CITY OF ALBUQUERQUE

December 16, 2022

RE: **Lot 18 Block 5 Unit 22 SAD 228**
Volcano Cliffs
6624 Sujeto Rd. NW
Rev. Grading and Drainage Plan Date: 8/9/2022
Pad Certification Date 12/7/2022 (D10D003K18)

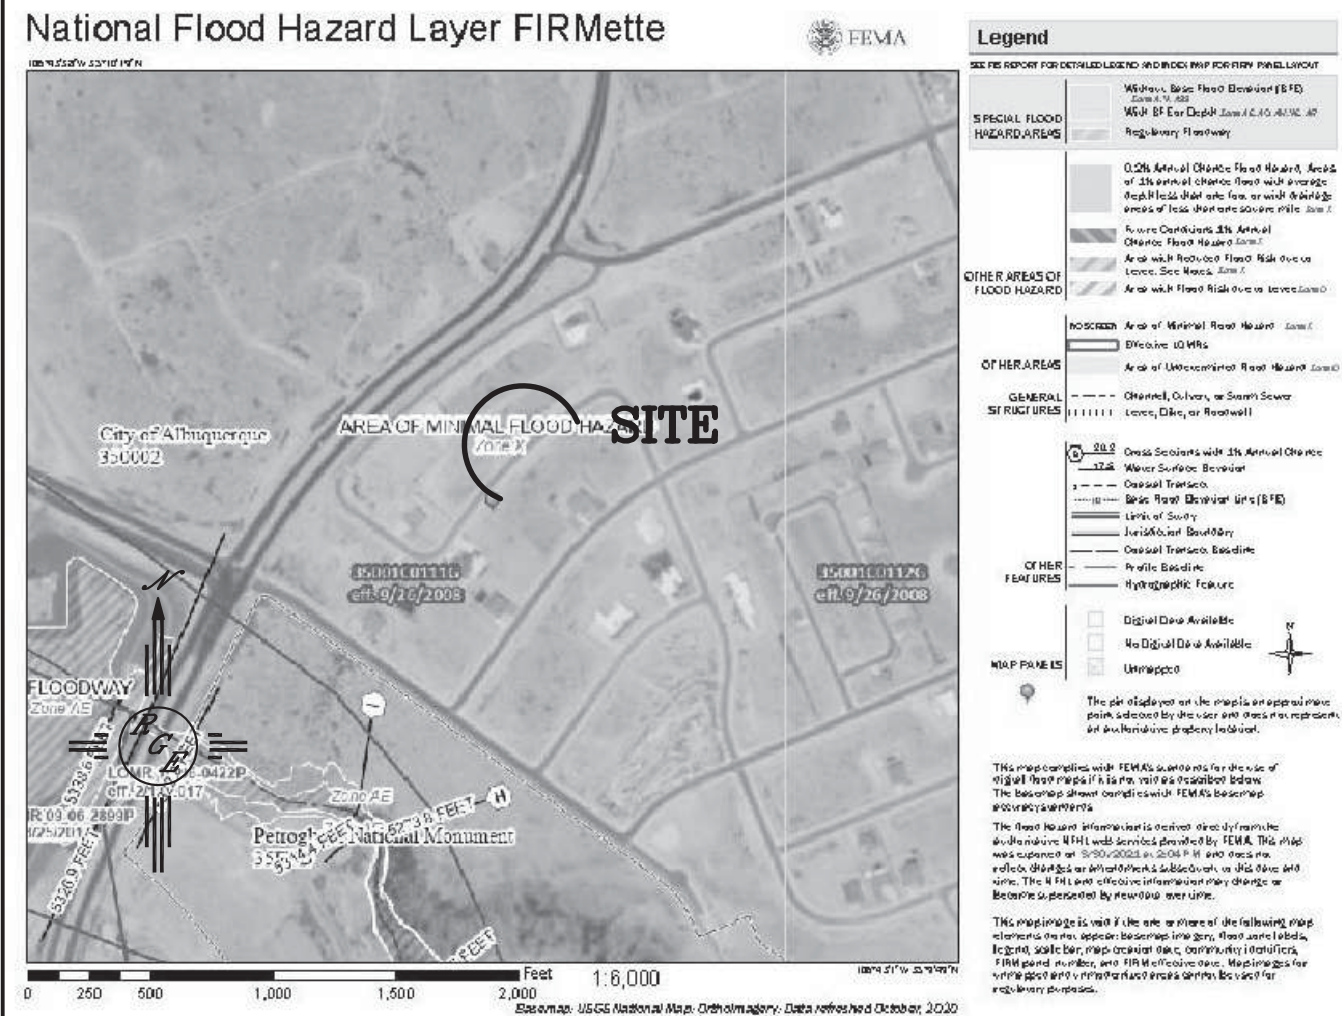
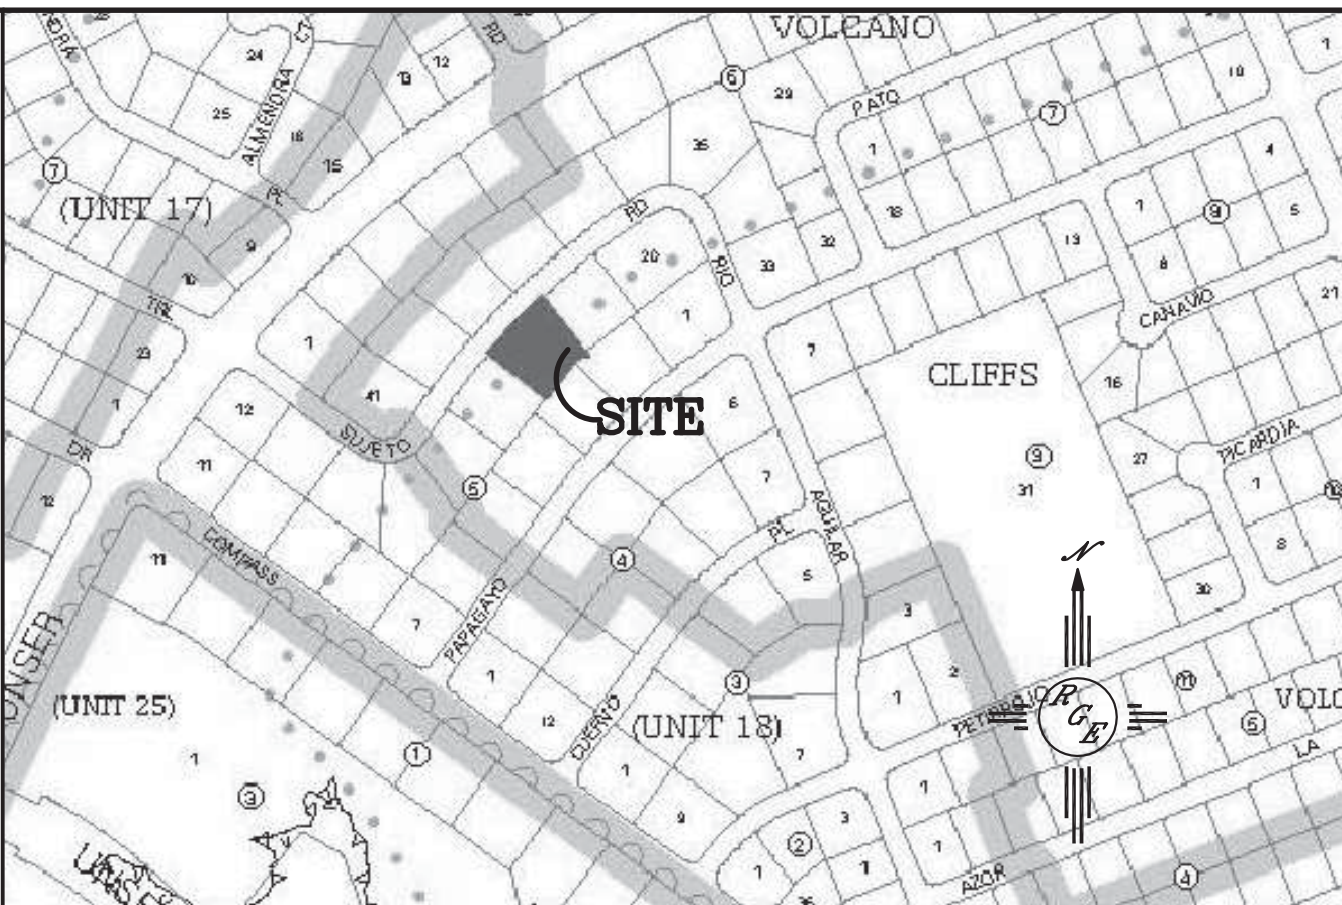
- Provide new land treatment values.
- Provide ponding areas for the home site, new concrete was added and exceeds the land treatment value for SAD 228.
